CITY OF ALBUQUERQUE

April 12, 2019

**Re: Vitality works,
8500 bluewater rd NW Albuquerque nm 87121
Request for Certificate of Occupancy
Transportation Development Final Inspection
Engineer's/Architect's Stamp dated 04-11-2018 (K10D009)
Certification dated 04-11-2018**

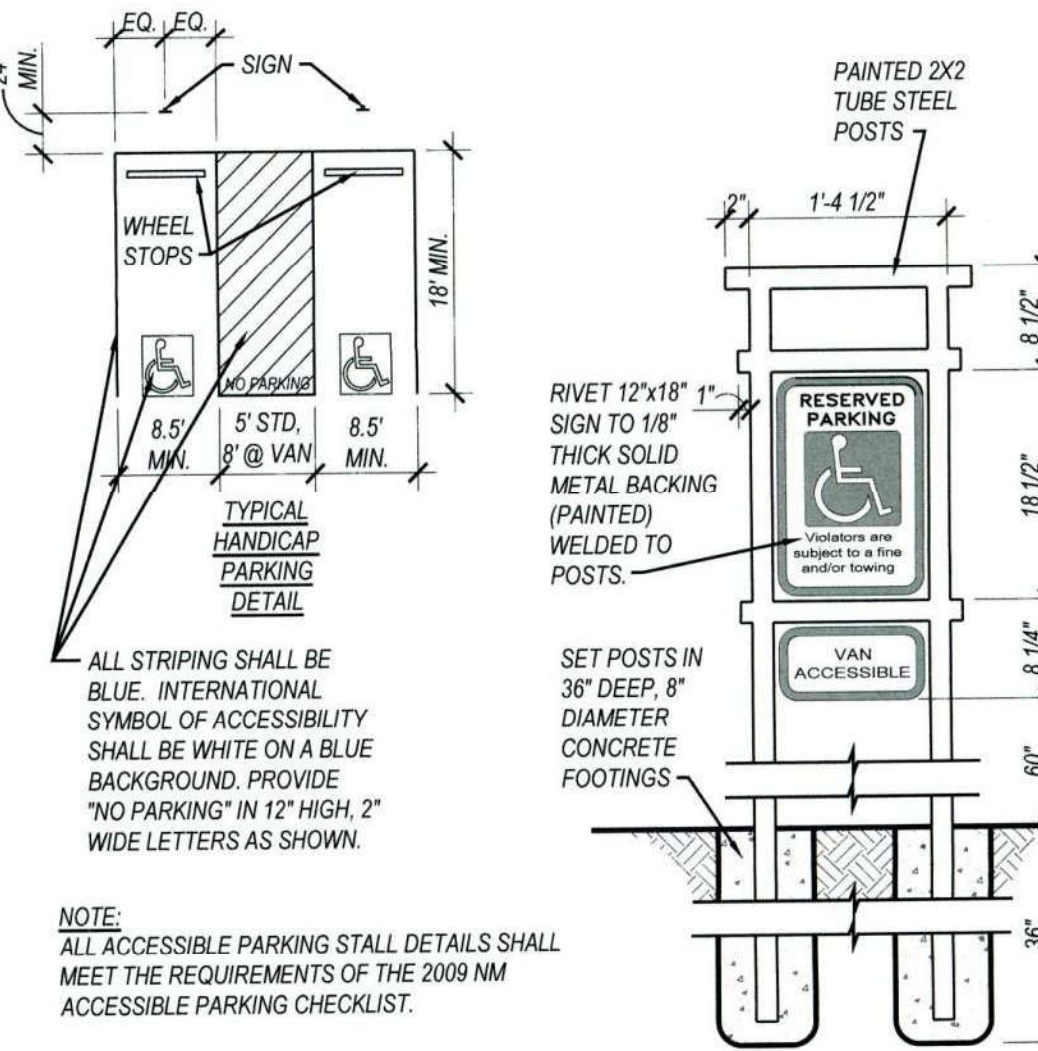
1. The ADA sign does not have the correct language. The ADA accessible parking sign must have the required language per 66-7-352.4C NMSA 1978 **"Violators Are Subject to a Fine and/or Towing."** Please call out detail and location of HC signs.
2. The ADA access aisles shall have the words **"NO PARKING"** in capital letters, each of which shall be at least one foot high and at least two inches wide, placed at the rear of the parking space to be close to where an adjacent vehicle's rear tire would be placed. (66-1-4.1.B NMSA 1978)
3. The parking structure to the west of the project site is under construction.
4. 6 ADA spots that are shown on the plans, they do not exist.
5. The existing entrance to the visitor parking needs to be built. It's not in good condition.
